**RE: Lot 15, Block 2, Unit 3, Tract 3, Eagle Rock Avenue
Grading and Drainage Plan
Engineer's Stamp Date 2-22-2015 (File: C20-D056B)**

Based upon the information provided in your submittal received 2-24-15, the above referenced plan cannot be approved for Building Permit until the following comments are addressed:

GRADING AND DRAINAGE PLAN

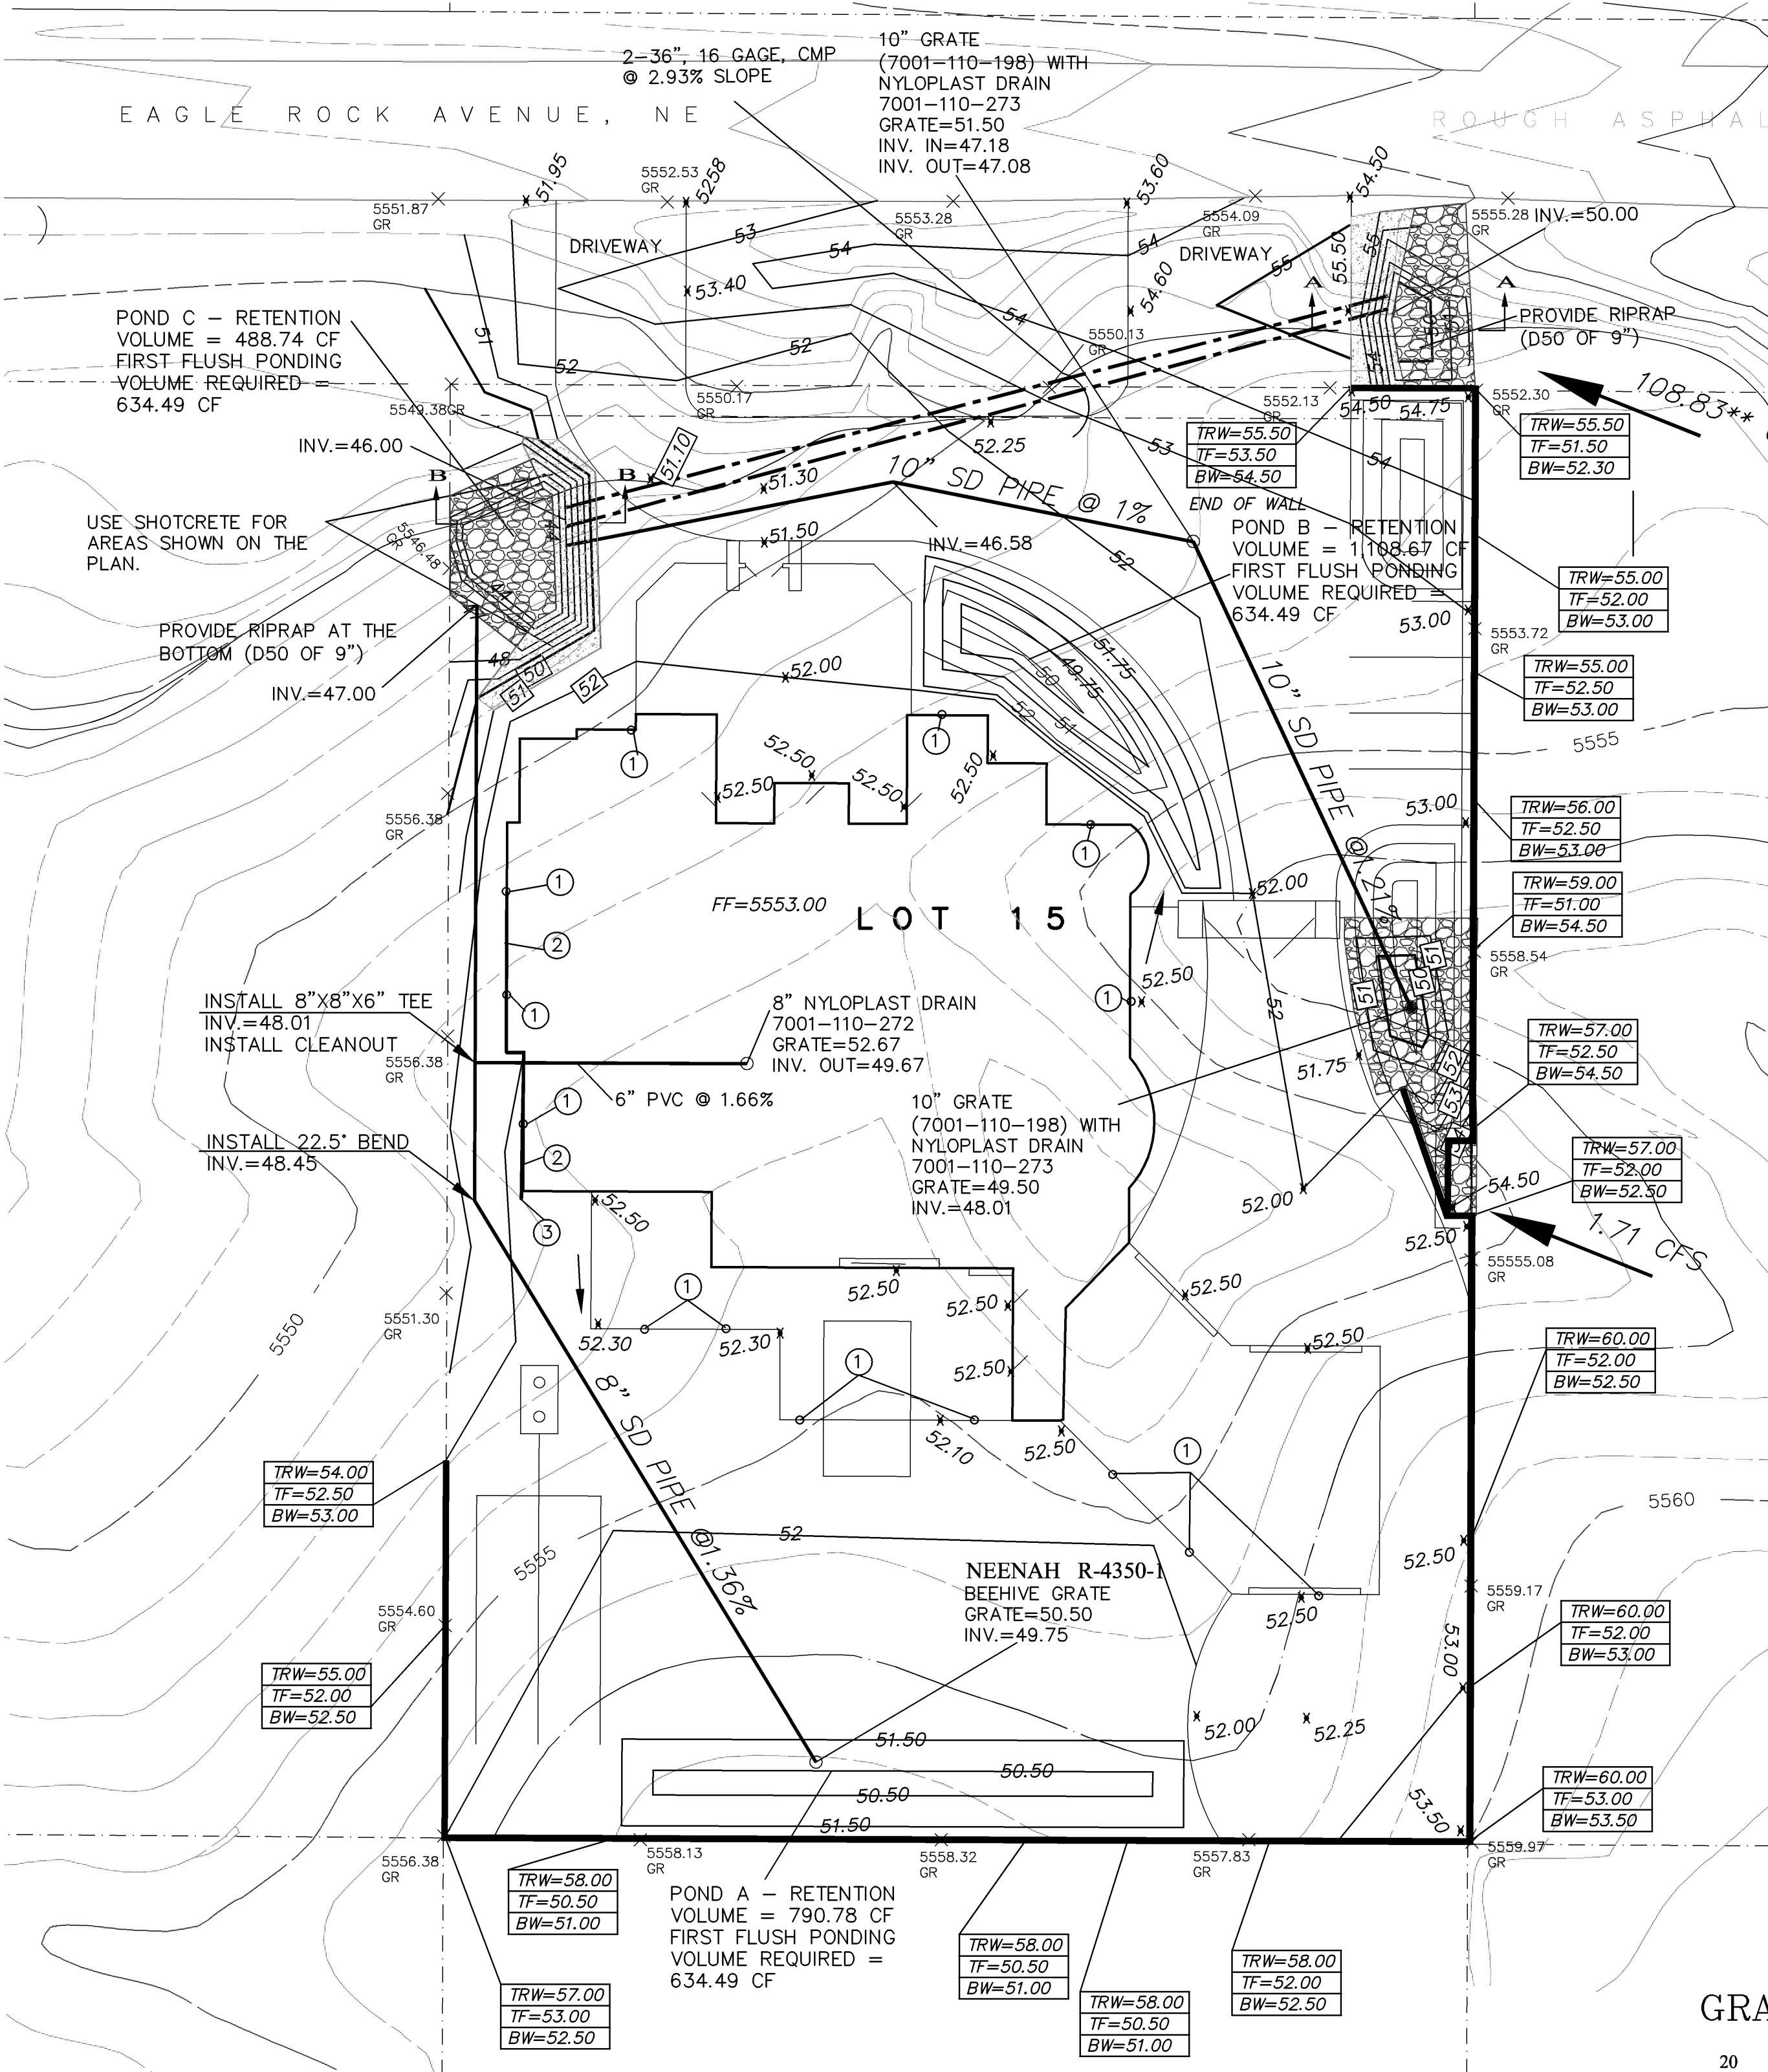
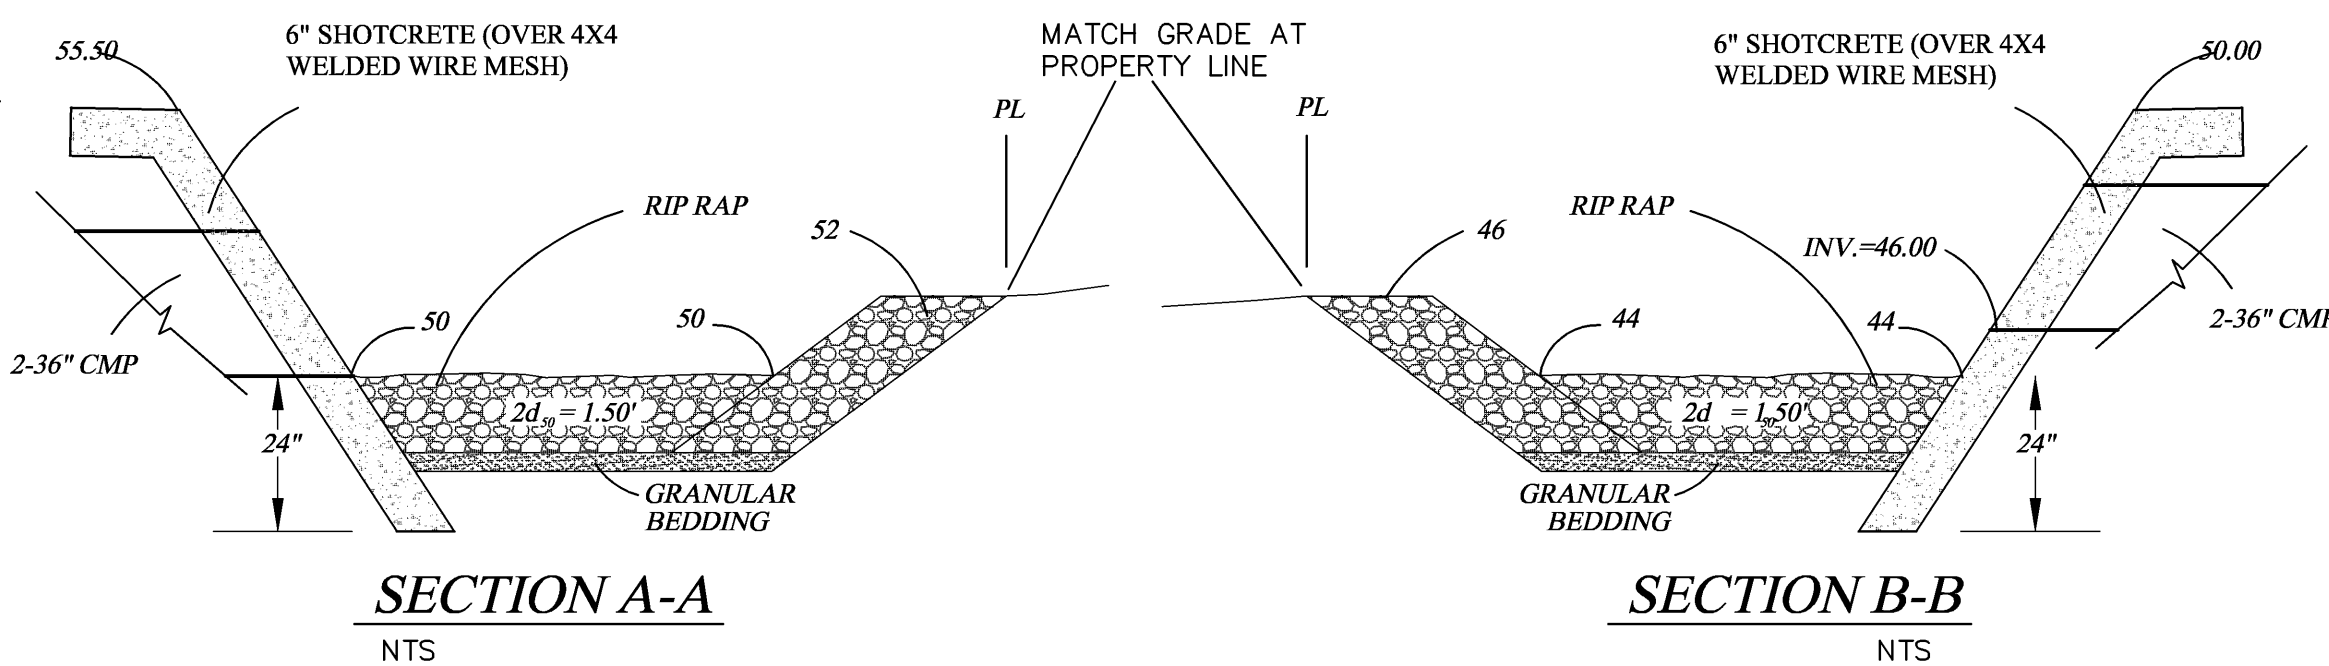
- 1) Provide a survey benchmark and existing spot elevations along the entire site perimeter.
- 2) Label the first flush volumes on the plan view. Show the roof drain locations. If part of the roof is draining to the north, locate some of this retention for the first flush immediately to the north of the proposed building, and label the volume of retention at this location.

- 3) How do the retaining wall heights match existing contour elevations? In addition to providing the top of retaining wall, provide the bottom of wall elevations in lieu of the top of footing elevations. (The elevations for the wall labeled along the southeast corner of the site look incorrect.)

- 4) Provide new contours tie-ins to existing contours at the site boundaries. Existing contours do not appear to represent improvements on Lot 18 to the south. On Lot 18, there is already an existing wall along the boundary, and the proposed wall construction conflicts with this. Also, show boundary line for subject property according to the legend.

- 5) Show calculations for the 1.71 cfs of off-site flow discharged to the site from the east. How is the flow getting to each of the on-site inlets? (The listed beehive grate elevations appear to be too high relative to the surrounding areas.) Provide more

- proposed contours. Include discussion of off-site flows within the "Proposed Conditions" write-up, and also include a very brief description of Basin 11.0 from the NAA Report, especially since it is a huge contributor of off-site flow.

- 6) On the downstream end of the pipe where the riprap is shown, provide calculations for determination of both riprap dimensioning and sizing. Specifically for the sizing, provide a "d50" of 9 inches or else provide a computation for determination of sizing. For the riprap dimensioning, there is a concern that there is not as long of a riprap section downstream of the two 36" pipes to handle the amount and the velocity of flow.

- Based upon these calculations, show the size and depth of riprap that is placed at the downstream and upstream ends of the pipe. If a longer section of riprap is required based upon these calculations, shorten the two 36-inch pipes to make more room for the riprap.

- 7) There is concern about scour where the shotcrete meets the riprap. Either provide a scour wall that extends a minimum of two feet below grade, or provide computations for the required depth of the scour wall.

- 8) Label the slope of the two 36" pipes on the plan view. If these are CMPs, call out the gauge of the pipes.
- 9) Show the proposed driveway location for the site and the proposed grades. Show adequate pipe cover at the point where the proposed driveway crosses over the 2-36" pipes.

- 10) Show proposed pipe run slopes for the proposed 8" pipe and the 100-year flow each individual pipe run is conveying. Provide capacity calculations for each of the individual pipe runs.

- 11) To reduce on-site flow from discharging to the site immediately to the west, provide an inlet for the 8" storm drain system to capture the flow from the southwest corner of the site.

- 12) Place headwall at the inlet location for the two 36" pipes.
- 13) The property owner is unable to directly access the beehive grate that is proposed on the east side of the site on the other side of the retaining wall. In lieu of this configuration for collection of off-site flows, it is recommended to collect the 1.71 cfs on the opposite side of the wall. Grade the site to make sure the flow gets into the grate, and ensure that there is flow away from proposed building.

- 14) In order to make the backyard area more usable, it is permissible to slightly raise the bottom grade of the backyard detention pond.
